Subject: SSD_7056 MOD 2

Re: SSD_7056 MOD 2

I am writing on behalf of residents at 8 Hickson Road, directly opposite the Campbell's Stores Building, for which this modification to the approval is sought. We ask that the concerns raised below be communicated to the Applicants for their response.

Figure 1 – Comparison of approved (above) and modified (below) Bay 11 plant room

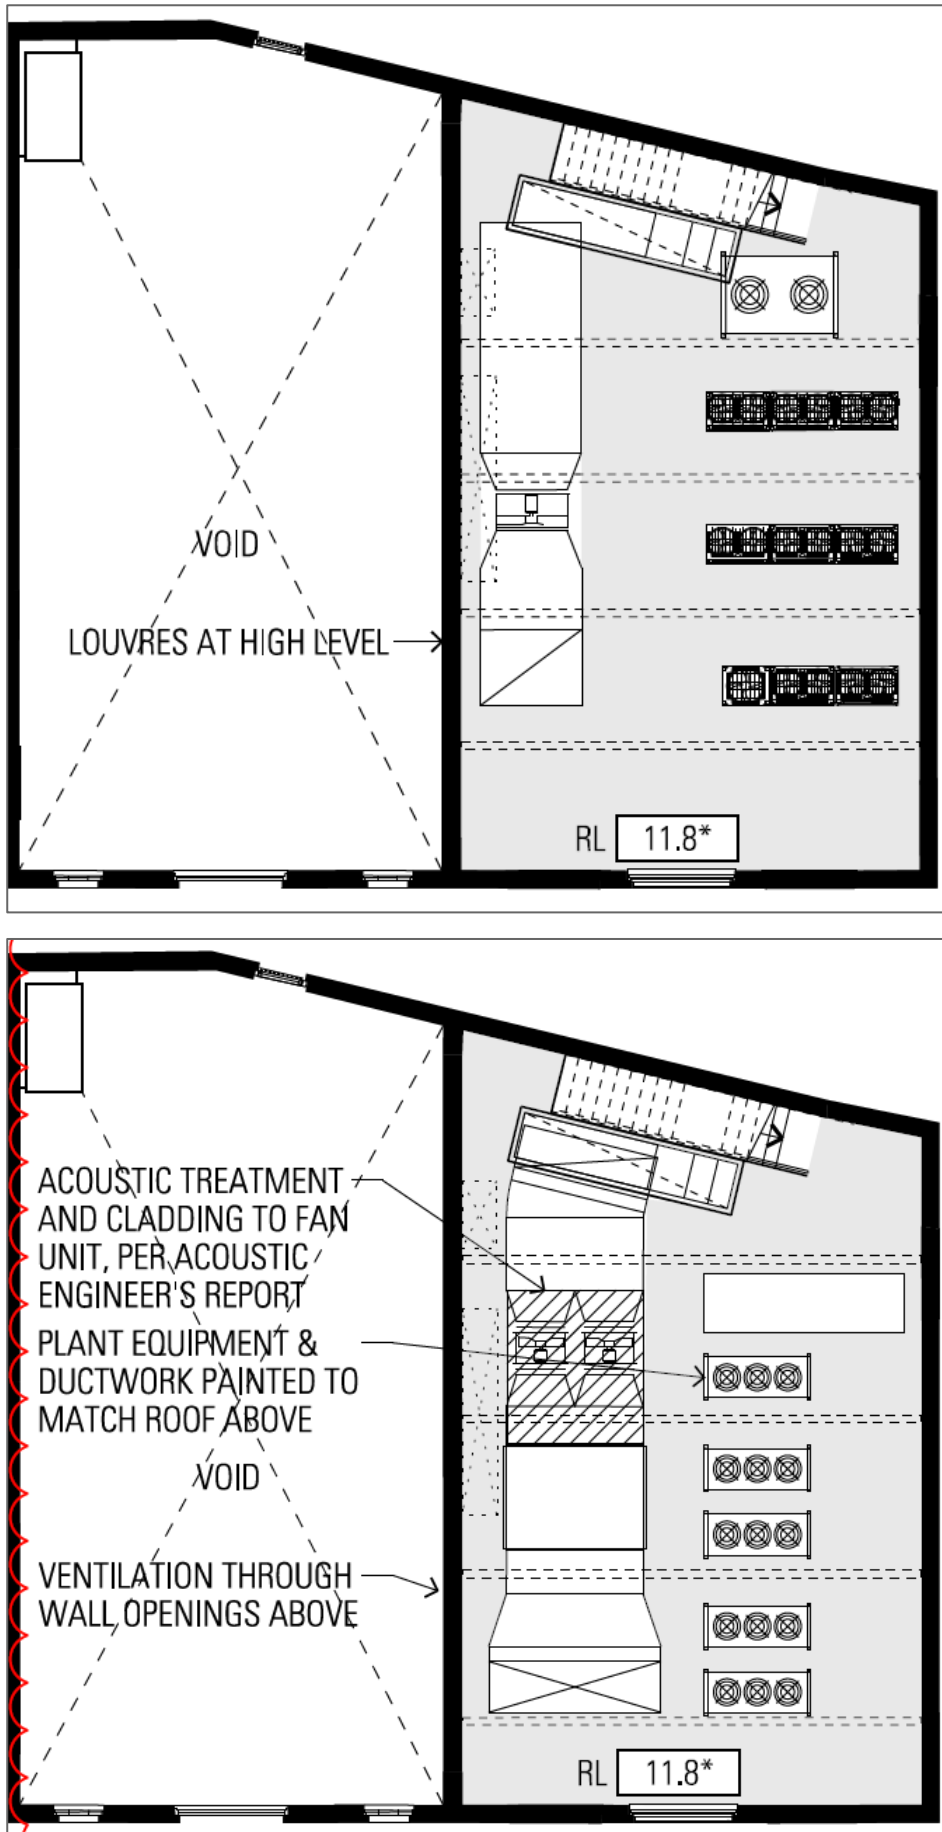
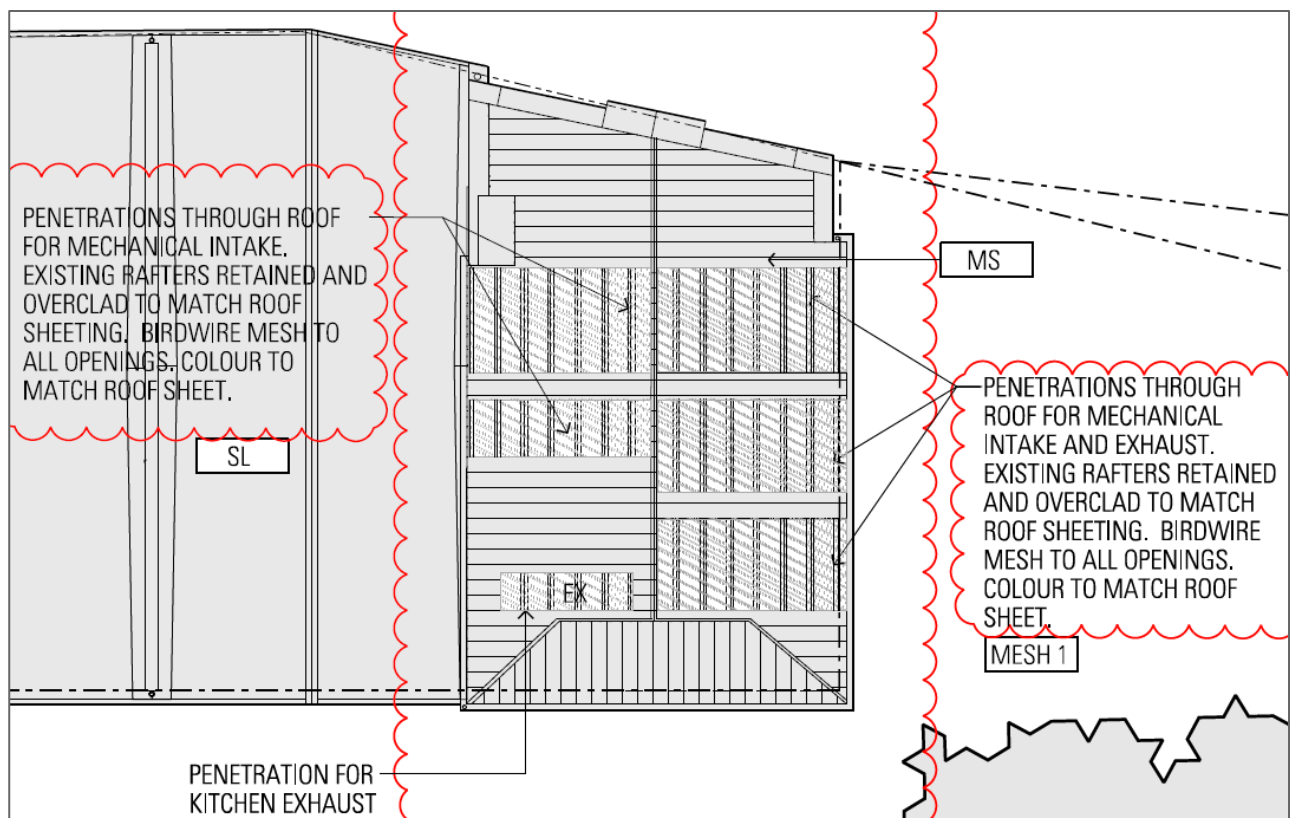
As we have stated in various submissions on the modification currently proposed (SSD_7056 MOD 2), leaving the roof line of Bay 11 with no more than a mesh covering will leave exposed the unsightly air conditioning and mechanical exhaust equipment that are intended to go there and also risk significant odour and noise pollution problems for us opposite and for any passers-by.

Of immediate concern to us is the fact that over the past week, Tallawaladah has installed significant equipment in the roof space of Bay 11. It seems almost as if the intention is to pressure the Department into approval of SSD_7056 MOD 2 by putting in place equipment that Tallawaladah claims can only be operable if the Department allows the roofline to have nothing more than a mesh covering.

Figure 2 – Comparison of approved (above) and modified (below) Bay 11 roof structure

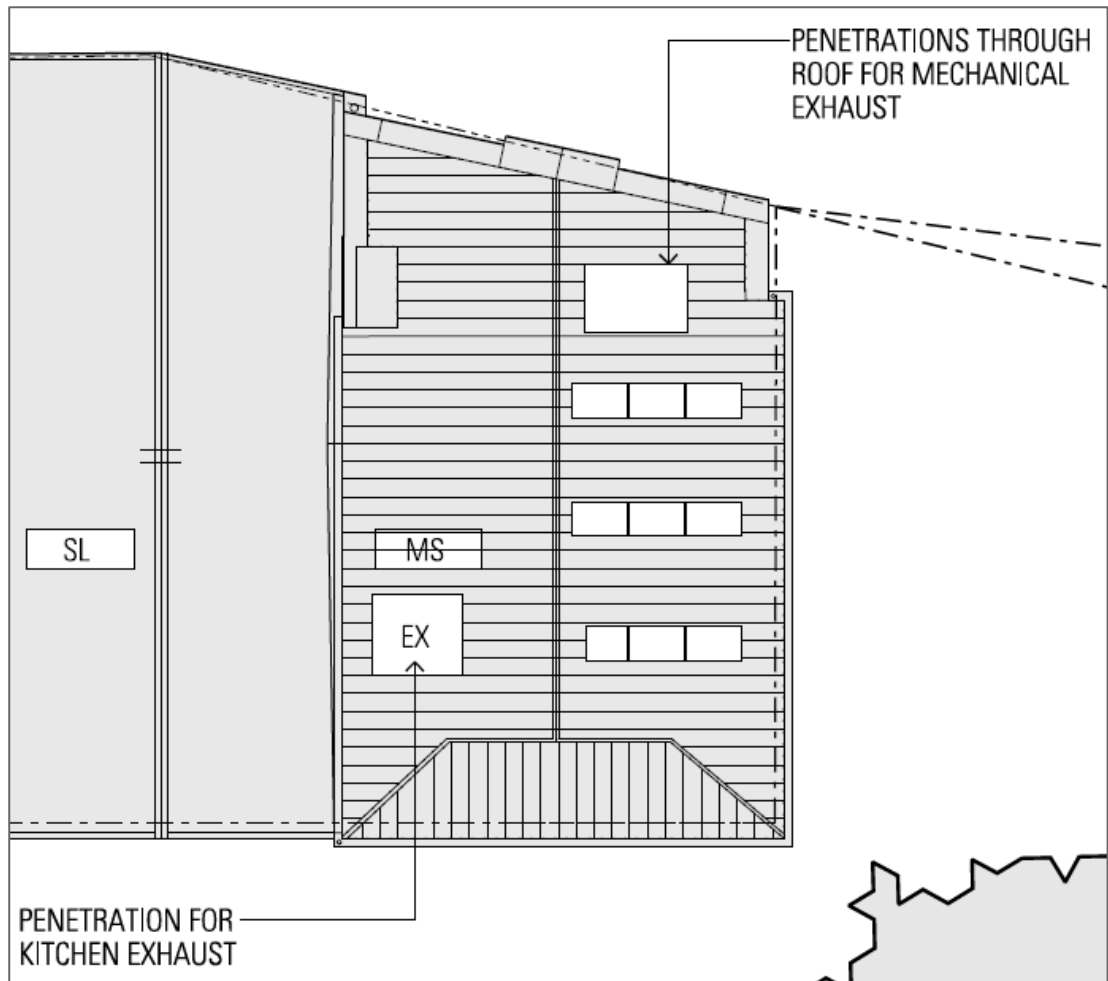
You have indicated that this application for a change to the roofing material is not due to be determined for at least another month. The Applicant claims that a mesh roof is the only means of making its proposed gas powered system work safely. If a mesh roof is all the Applicant can offer, then the air conditioning and mechanical exhaust should be located at the southern end of the building, where there is no impact on local residents. Alternately, it should be properly enclosed, and if necessary, powered by electricity.
